Recommendation Report for Planning Permission for Works or Extension to a Dwelling

REF NO: BR/27/26/HH

LOCATION: 95 Longford Road
Bognor Regis
PO21 2TA

PROPOSAL: Dropped kerb and new vehicular access.

Sheet 1 b of 1

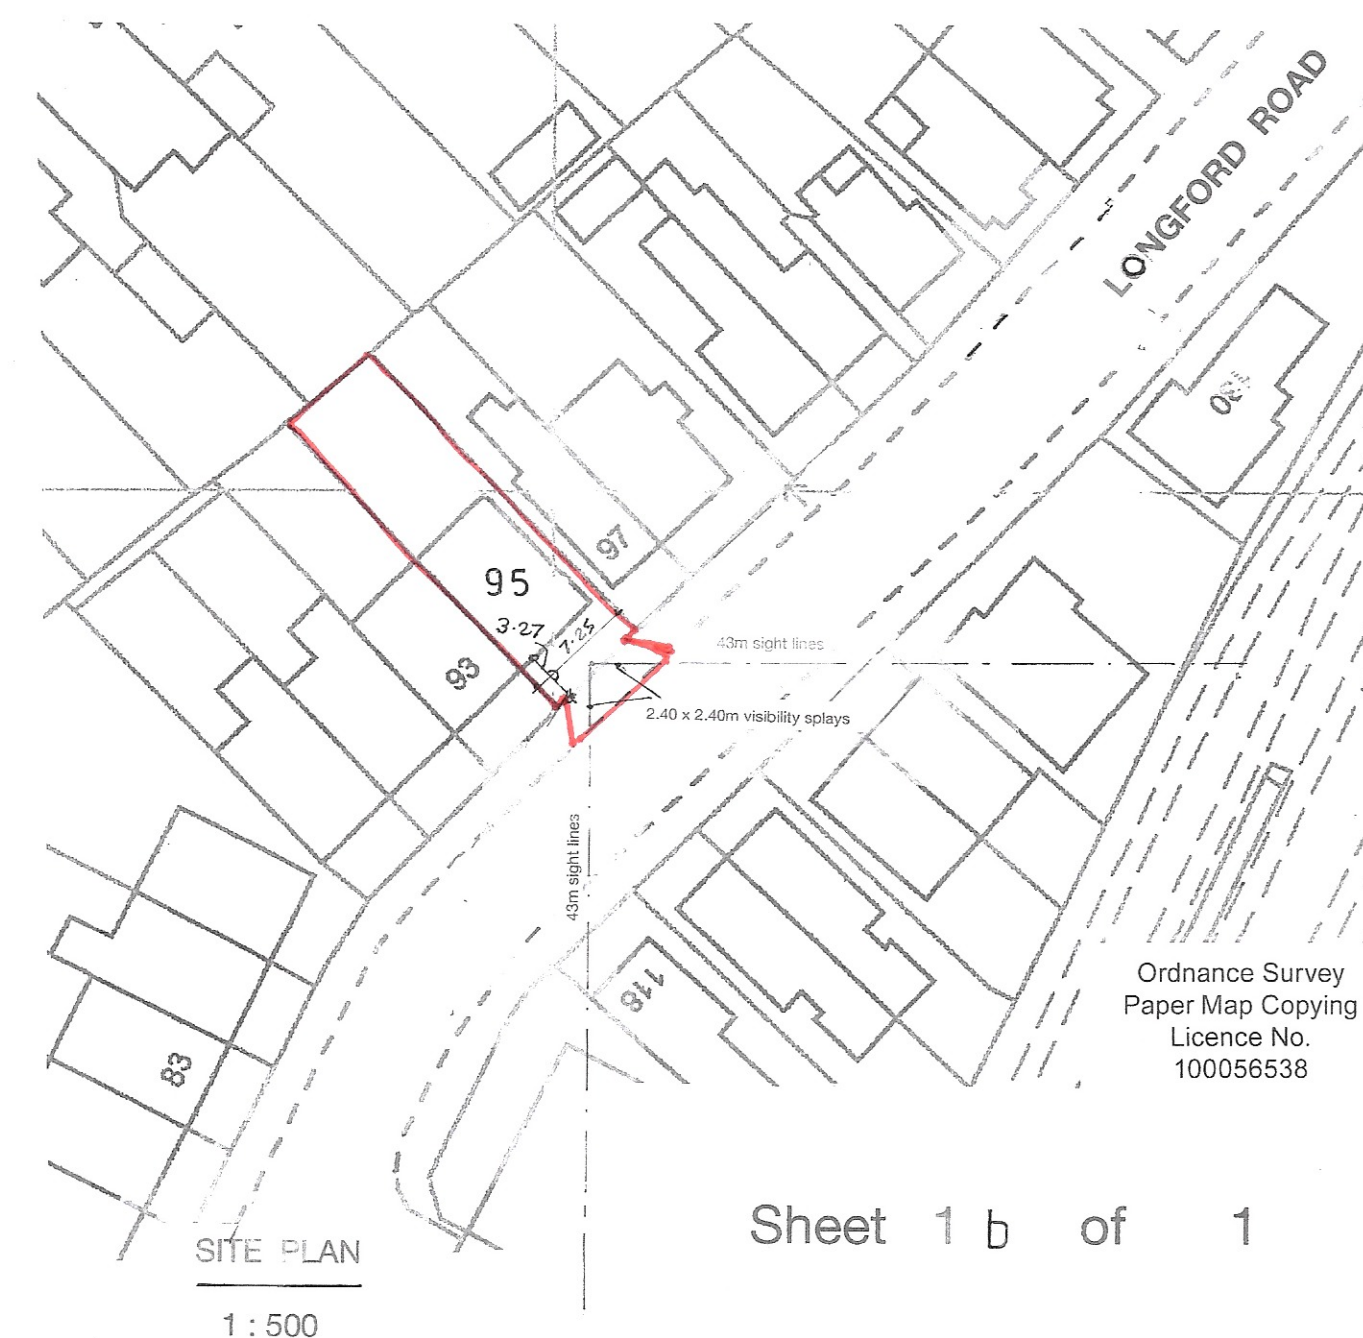
From inspection of the plans, there are no apparent visibility concerns with the proposed access point. The proposed access works including relocation of existing bollard would be subject to a licence obtained through the local WSCC Highway Area Office and constructed to a specification agreed with the local WSCC Highway Area Engineer.

I note that under current Highway Area Office guidance for Vehicle Crossovers (VCOs), licences are only granted for accesses with hardstanding depths of at least 4.8m. The submitted plans demonstrate a hardstanding depth of 3.27m, which is too small to accommodate a parking space of 2.4m x 4.8m. Therefore, the applicant should be advised that a licence for the proposed access works is unlikely to be granted.

The site includes a semi-detached dwelling on the western side of Longford Road. The proposal is for a dropped kerb and new vehicular access. The front garden is entirely hardstanding, measuring 3.27m in depth and 7.2m in width, therefore lacking the depth to accommodate a policy compliant parking space as per West Sussex County Council Guidance or the parking standards described in the Arun Design Guide (ADG).

- 5 INFORMATIVE: West Sussex County Council Highways have advised that a Vehicle Crossover Licence is unlikely to be granted due to the size of the frontage, which could not accommodate a policy compliant parking space. This would mean the planning permission hereby granted could not be implemented.
